22/03873/F

**Land North And Adjacent To Mill Lane Stratton Audley**

**Installation and operation of a renewable energy generating station comprising ground-mounted photovoltaic solar arrays and battery-based electricity storage containers together with a switchgear container, inverter/transformer units, Site access, internal access tracks, security measures, access gates, other ancillary infrastructure and landscaping and biodiversity enhancements.**

Berkshire, Buckinghamshire and Oxfordshire Wildlife Trust

Client
JBM
Project:
Padbury
Drawing Title:
Site Layout Plan - 1 of 4
Drawing No: 1051745-ADAS-XX-XX-DR-PL-8001
Scale: 1:1000 at A1
Drawn by: A.F. Date: 26/07/22
Checked by: D.H. Date: 26/07/22

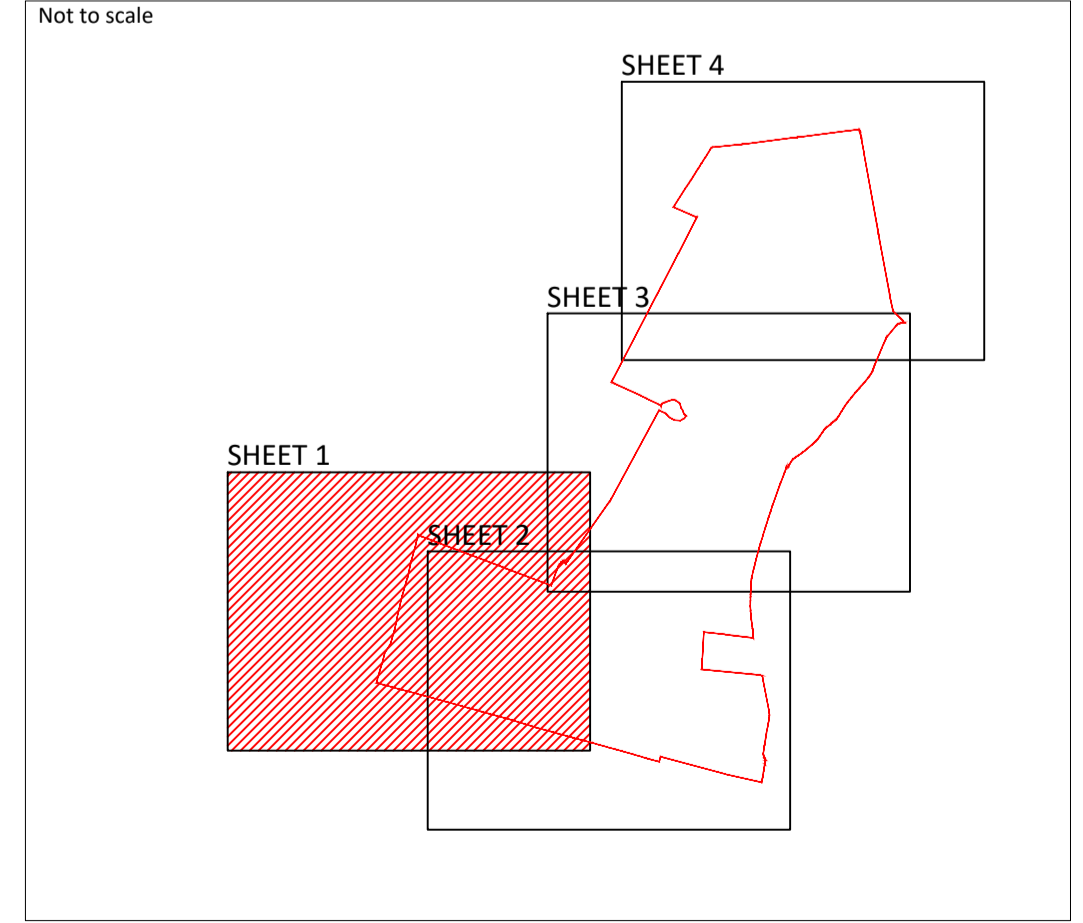
Whilst standing by all our original response we would particularly like to draw attention to the fact that the updating of the Landscape and Habitat Management Plan that has taken place provided the opportunity to address our concerns set out in section 3 in relation to the seed mix and management regime for the main area of grassland (49.27 ha) within the panel area, but that has not taken place so our concerns remain.

*“In particular we are concerned that the seed mix (Habitat Aid ‘Grazing Meadow Seed Mix’ or similar) to be sown within the solar array fence which will cover the vast majority of the site (49.27 of 58.05 hectares) is a grazing mix rather than a wildflower seed mix and contains a high proportion of perennial ryegrass. It therefore may not achieve the predicted other neutral grassland in moderate condition within five years (see paragraph 4.2.4 of the applicant’s BNG statement) especially as most of this area will be shaded by the solar panels.”*

The same seed mix is still being recommended in the updated Landscape and Habitat Management Plan, as set out in section 3.7. As we said before we have concerns that such a “grazing mix” as opposed to a “wildflower mix” (the latter being proposed, which we welcome, for the remaining 7.49ha around the edges), may not achieve the criteria for Other Neutral Grassland - Moderate condition, which would require it to pass Criterion A in the condition scoring criteria for Medium, High and Very High Distinctiveness grasslands.

As set out in our original response (appended) we consider that with the considerable biodiversity impact of what is in effect the semi-industrialisation of a rural area of great value for wildlife, then the compensation should seek to create the highest standard of habitat that can reasonably be achieved within the solar array compounds, as opposed to only the small area outside them, and propose a species-rich wildflower grassland using an appropriate seed mix and management within the solar array compounds.
